# Longridge Town Council

15 July 2011

| 3/2011/0476                                                                                                                                                                                                                                                                                                                                             | E H Booth & Co Ltd, Berry Lane, Longridge, PR3 3NH |
| <p>Two externally illuminated fascia signs.</p>                                                                                                                                                                                                                                                                                                         |                                                    |

project				
Extension to Booths Supermarket Berry Lane Longridge				
by	chk.	date	scale	sheet size
JRB	DS	2011 05.23	1:50	A3
use				
Signage plan

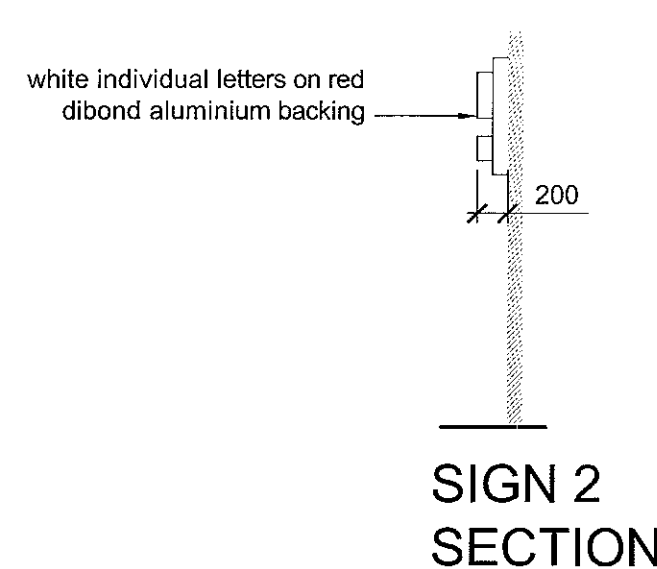
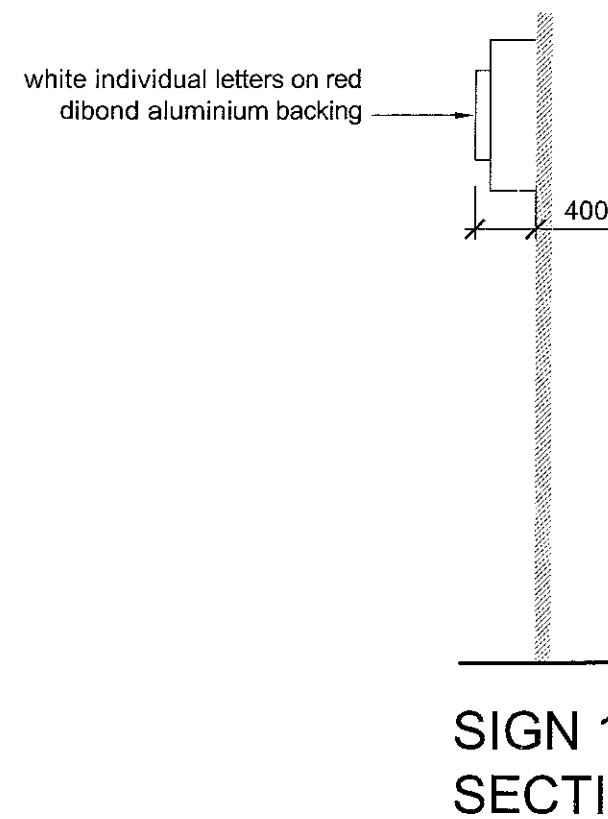
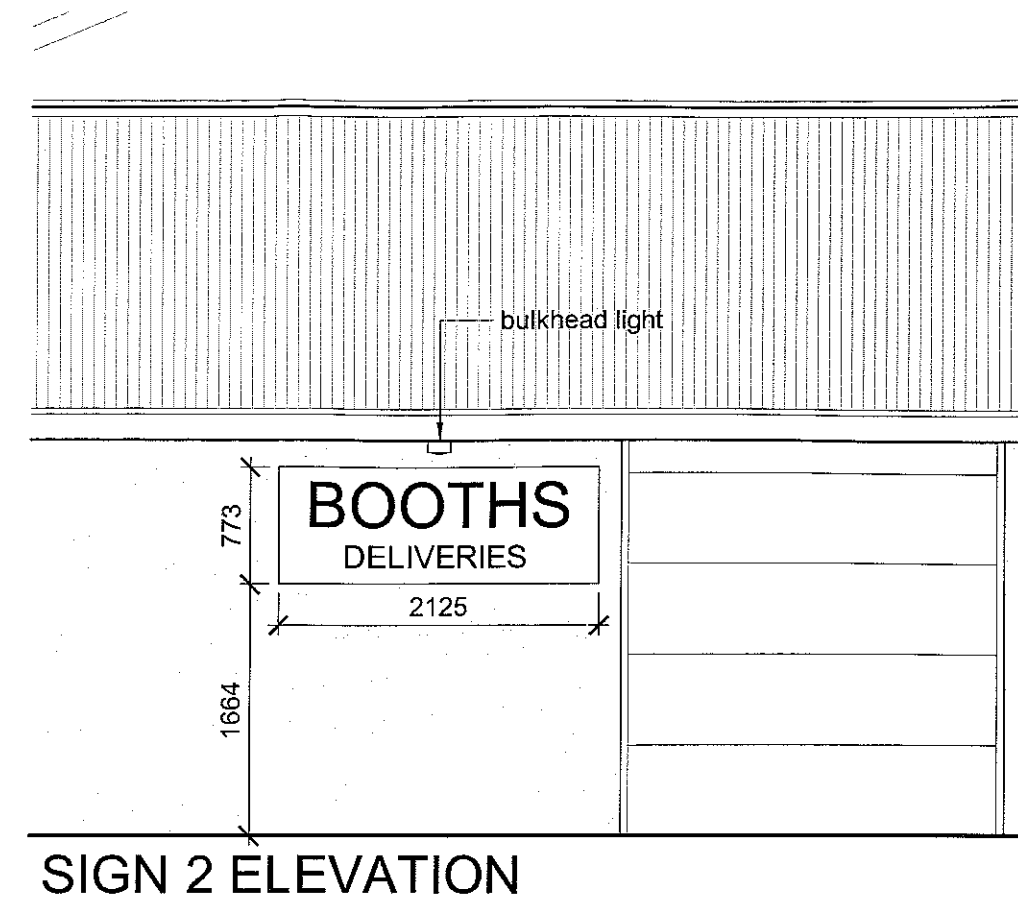
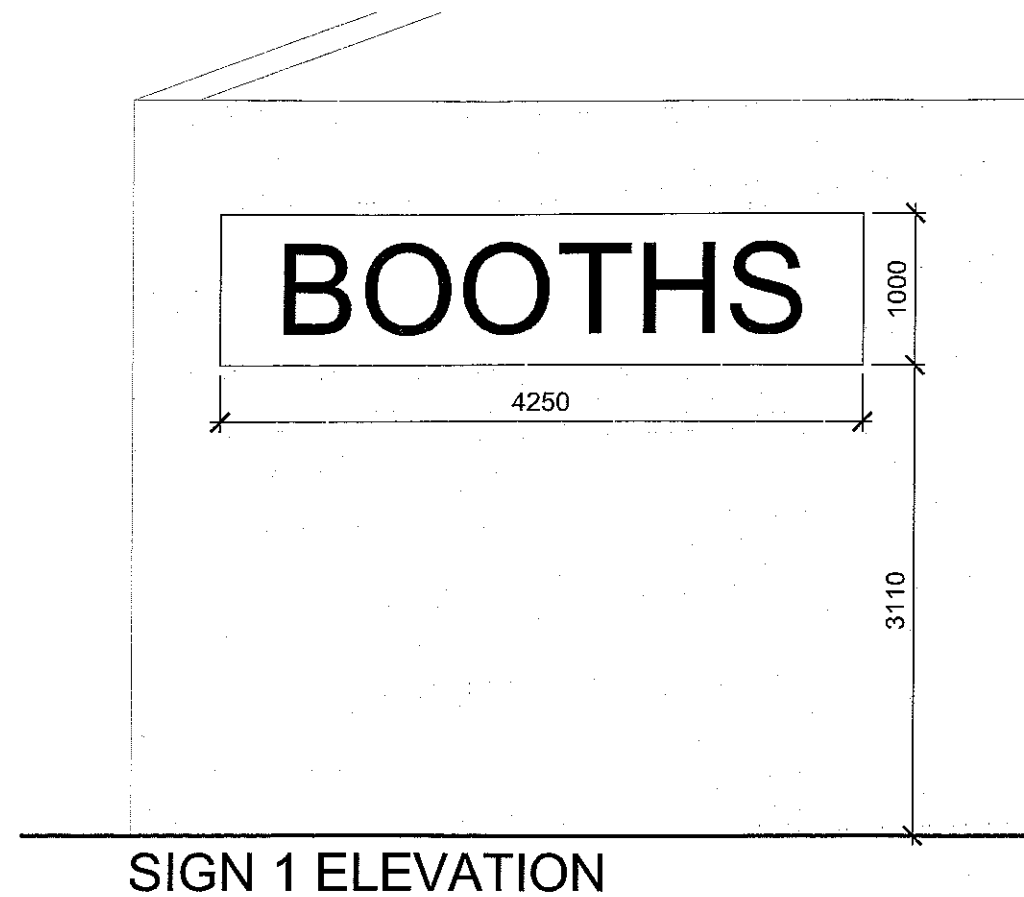
| <p>It was resolved that the Council has <b>no objection</b> to this application subject to the general comment at point 2 above (application no. 3/2011/0475) about light pollution. It is suggested that if approval is to be granted this should be conditional on the illuminated signs being switched off when the shop is closed to customers.</p> |                                                    |
